Subject: Geotechnical Third Party Review
5637 E. Mercer Way
Mercer Island, Washington
Perrone Consulting Project #15124

This letter summarizes our response to the Geo Group Northwest, Inc. July 30, 2015 letter that addresses our third party review comments (Perrone Consulting, Inc., P.S., June 12, 2015) for the proposed residential project at 5637 East Mercer Way, Mercer Island, Washington.

P1.0
 SHORING/PIN PILE DETAILS

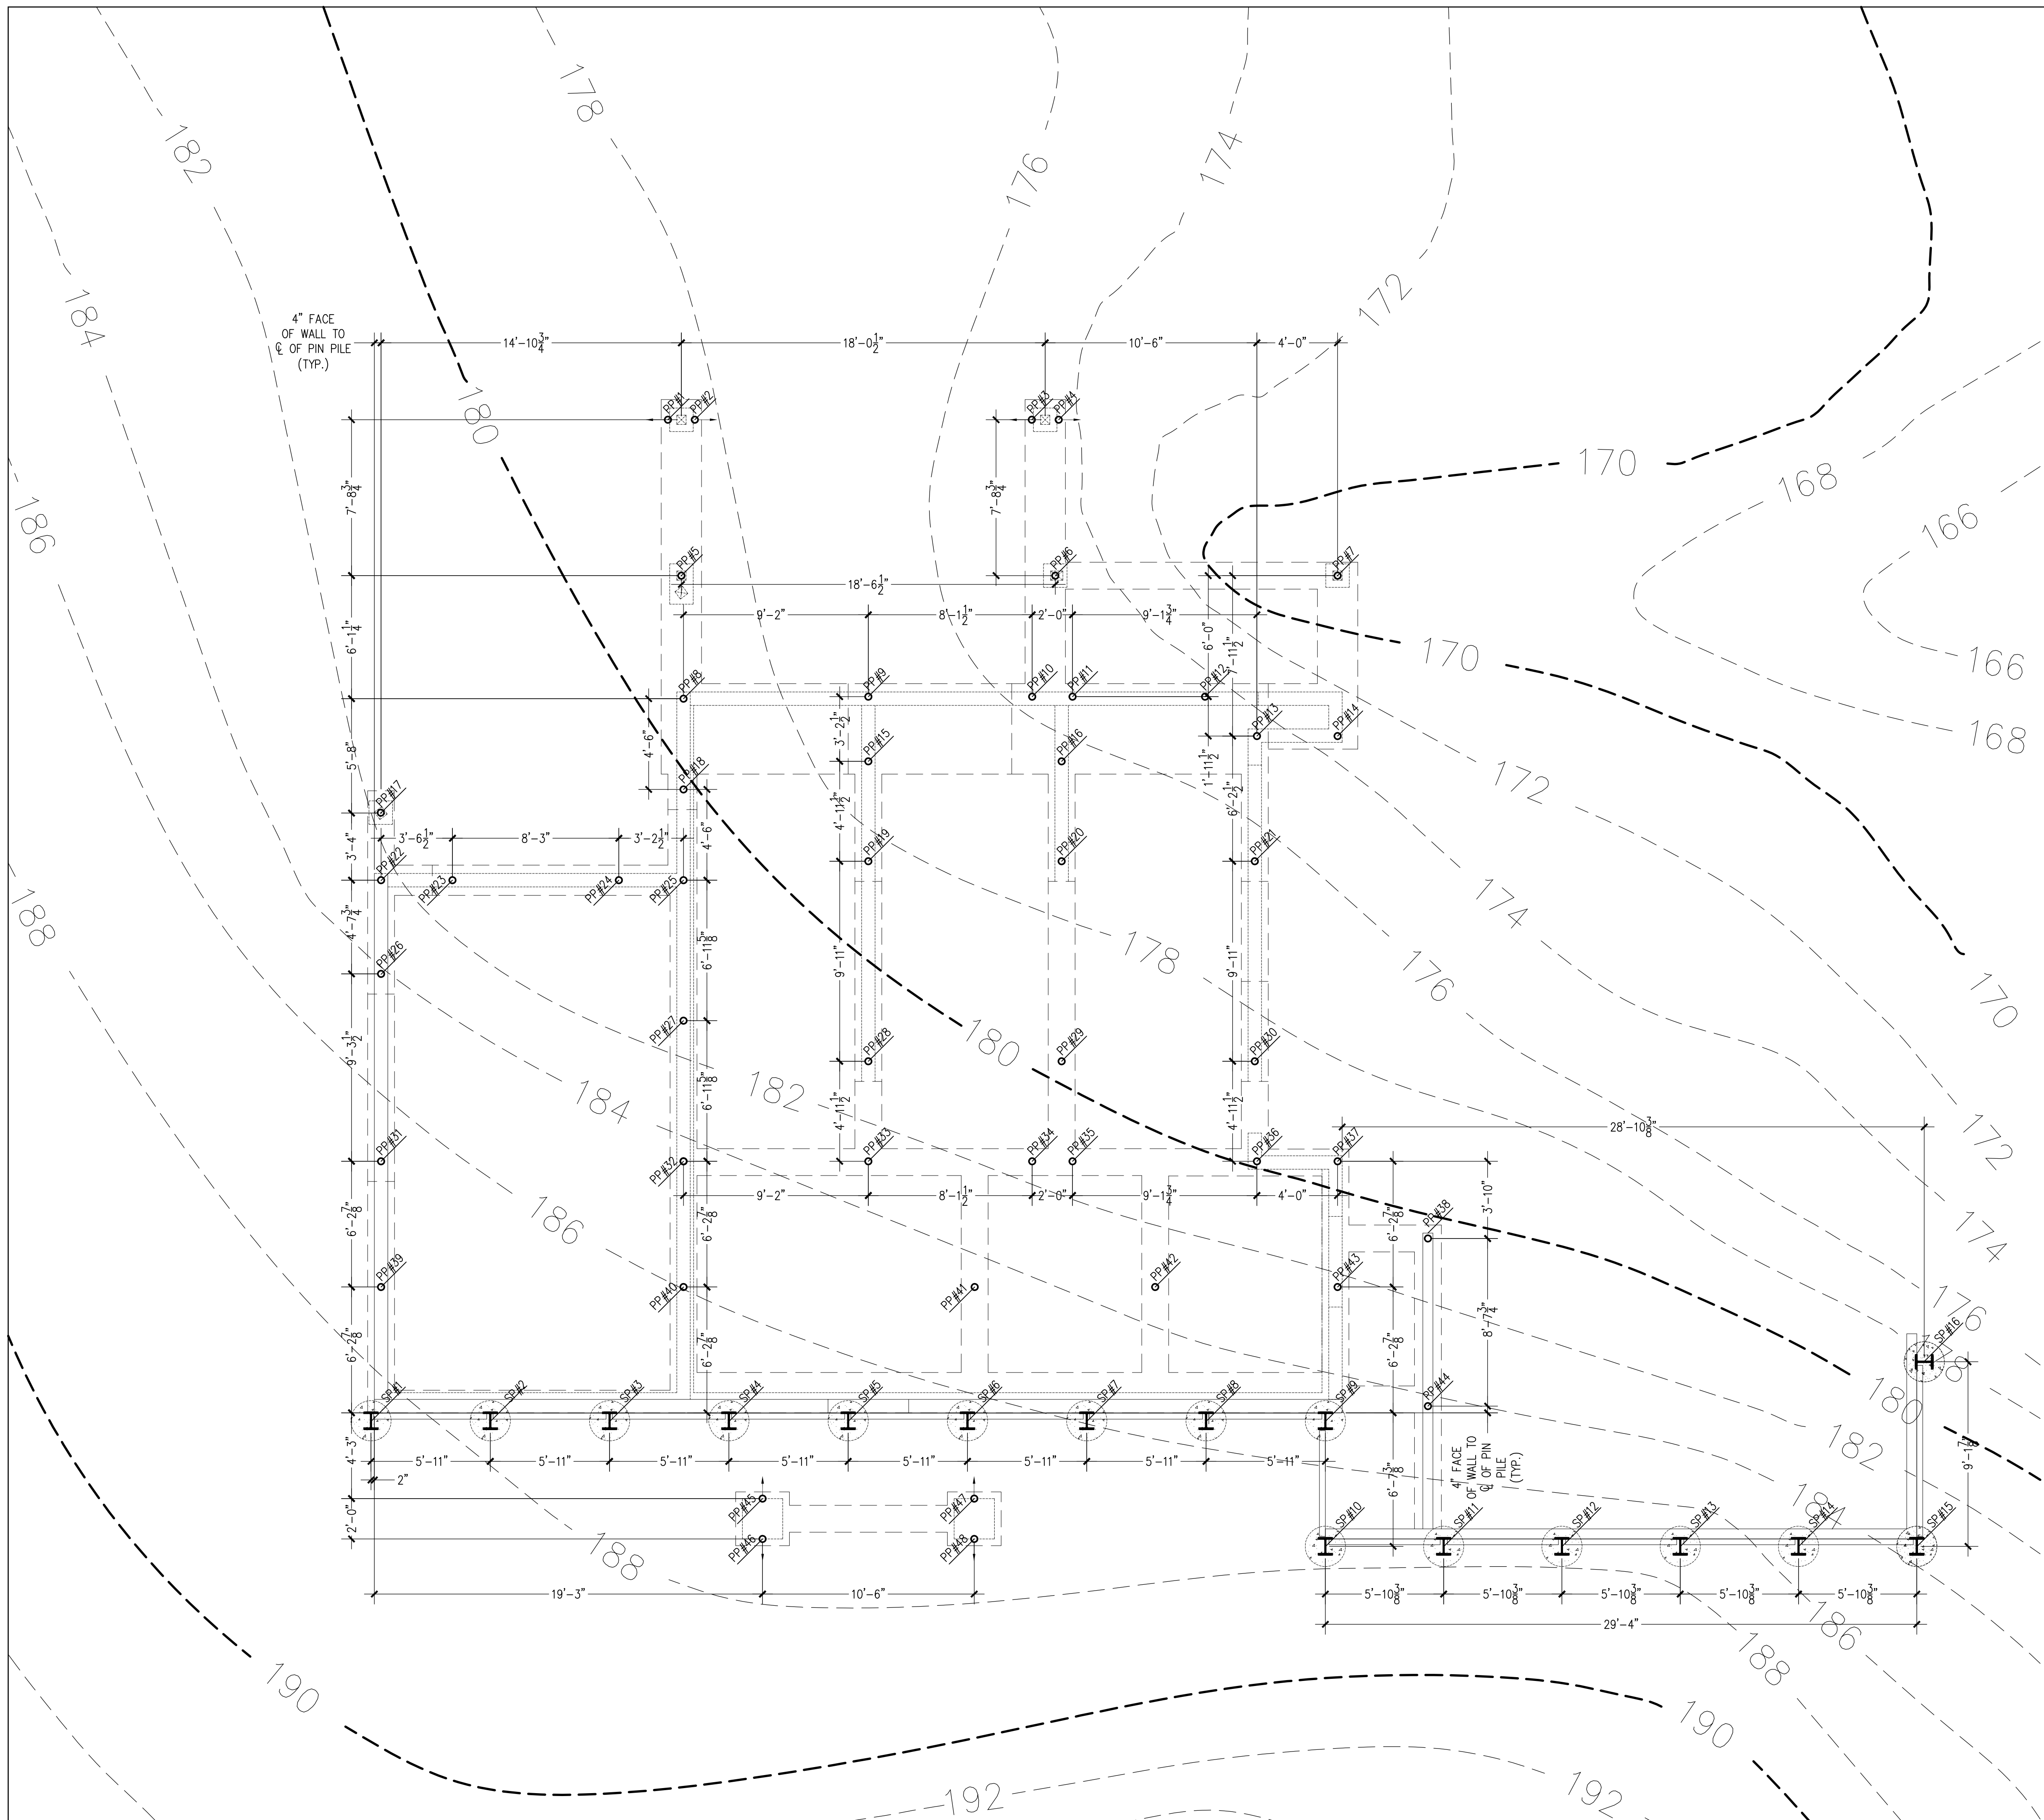
5. Provide an estimate of downdrag loads on the pin pile foundations due to liquefaction and settlement of 15 to 20 ft of loose soil around the pin piles.
